From: [Bill Booker](#)
To: [A38 Derby Junctions](#)
Cc: [Tim Hancock](#); [Alun Jones](#); [Simon Cope \(simon.cope@eurogarages.com\)](mailto:simon.cope@eurogarages.com)
Subject: TR010022 - A38 Derby Junctions highway improvement scheme
Date: 24 June 2020 17:15:35

**A38 DERBY JUNCTIONS HIGHWAY IMPROVEMENT SCHEMES
UNIQUE REF 20022836**

We write on behalf of Euro Garage Limited (EGL) in respect of the anticipated adverse effect upon the petrol filling station at the Markeaton interchange of the proposals by the applicant to materially amend the A38/A52 junction and to close the principal ingress as well as alter the remaining access arrangements serving the overall site.

(MARKEATON JUNCTION)

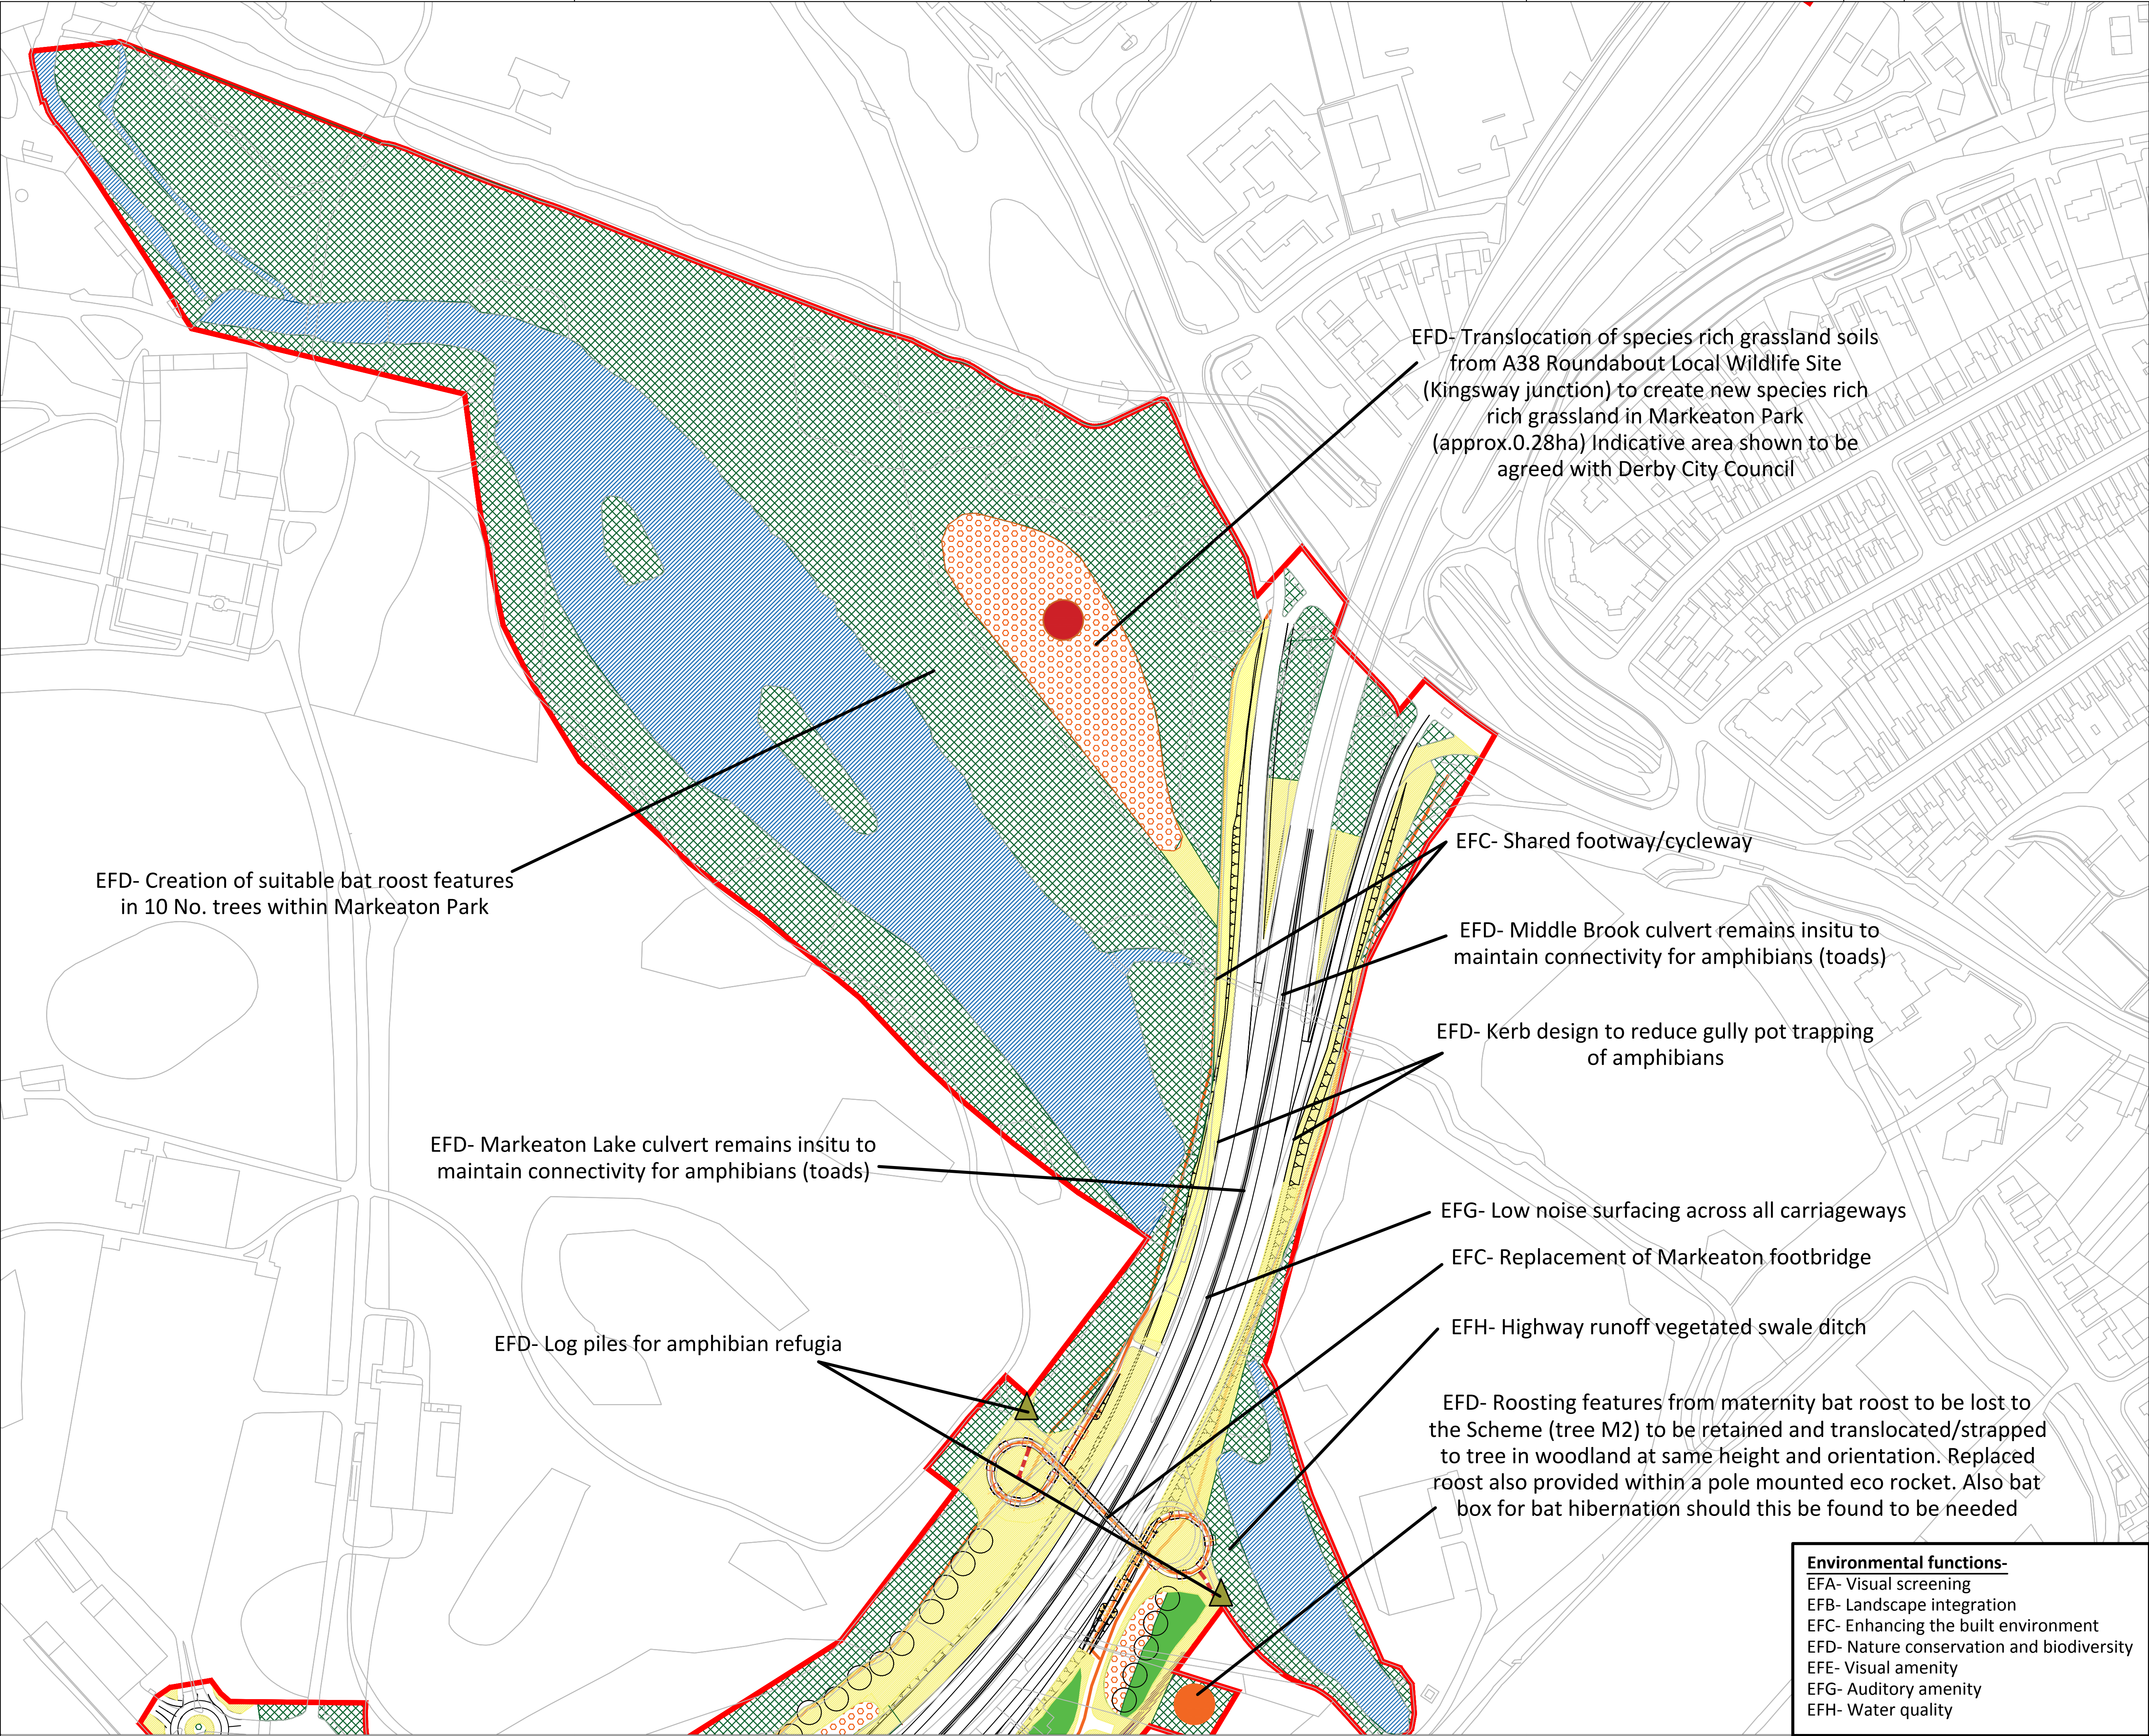
The scheme as designed would include a substandard radius for the left turn into the overall site and for EGL it becomes in effect a U turn into the forecourt. The tightness of the turn has been acknowledged by all parties and leads to the need to widen the bellmouth in an attempt to facilitate the swept path of goods vehicles/ fuel tankers and the like.

As a result of the tight radius for the left turn into the access the crossing width for pedestrians at the bellmouth will be 24m which is considered excessive despite the introduction of a splitter island in the bellmouth of the junction. There are safety issues for pedestrians at this crossing point as a straight crossing route is proposed and these issues appear not to have been fully considered. EGL instructed an Independent Safety Auditor to review the extract of the Stage 1 Road Safety Audit supplied by the Applicant. The extract related to the A52 junction and it was clear that the EGL auditor had meaningful concerns with the extract document. As noted earlier there will be an intensification in the left turn into the site from the A52 due to the loss of the ingress from the A38. Indeed, the Applicants modelling of the access indicates an increase of 100 vph turning left into the site during the peak highway periods.

The turn for a tanker or an HGV into the forecourt from the A52 south is significantly below the normal design radius of 10m recommended by the Freight Transport Association. As such it is considered that the maintenance issues associated with the wheel scrub from these large vehicles is a material concern. Additionally, the swept path assessments undertaken by the Applicant will require precision by drivers to achieve in order to make the manoeuvre to ensure that vehicles do not stray into lane 2, strike the near side kerbs or overrun the footway with

It is further noted that the Applicant considers that the access proposals are similar to that which currently exist onto the A52. Clearly, whilst there are some similarities in that both existing and proposed accesses are onto the A52 there are also significant differences in that the current arrangement is a priority style junction with a one way circulation around the half moon island and ingress and egress movements occur at different points onto the A52. The angle of the turn into the EGL forecourt is much tighter than the existing arrangements. The removal of the ingress from the A38 is anticipated to lead to an intensification of use of the access by left turning vehicles. The Applicant's own modelling of the junction identifies an increase of 100 vph turning left into site. The introduction of traffic signals in the proposed access will lead to traffic queuing to leave the site, as per the Applicant's traffic modelling assessments. Vehicles turning into the site from the south will quickly face a decision whether to enter the forecourt or McDonalds and with the very tight radius for the left turn in there is a risk of loss of control or nose to tail shunts due to misunderstanding the layout. This could also involve vehicles waiting to leave the site.
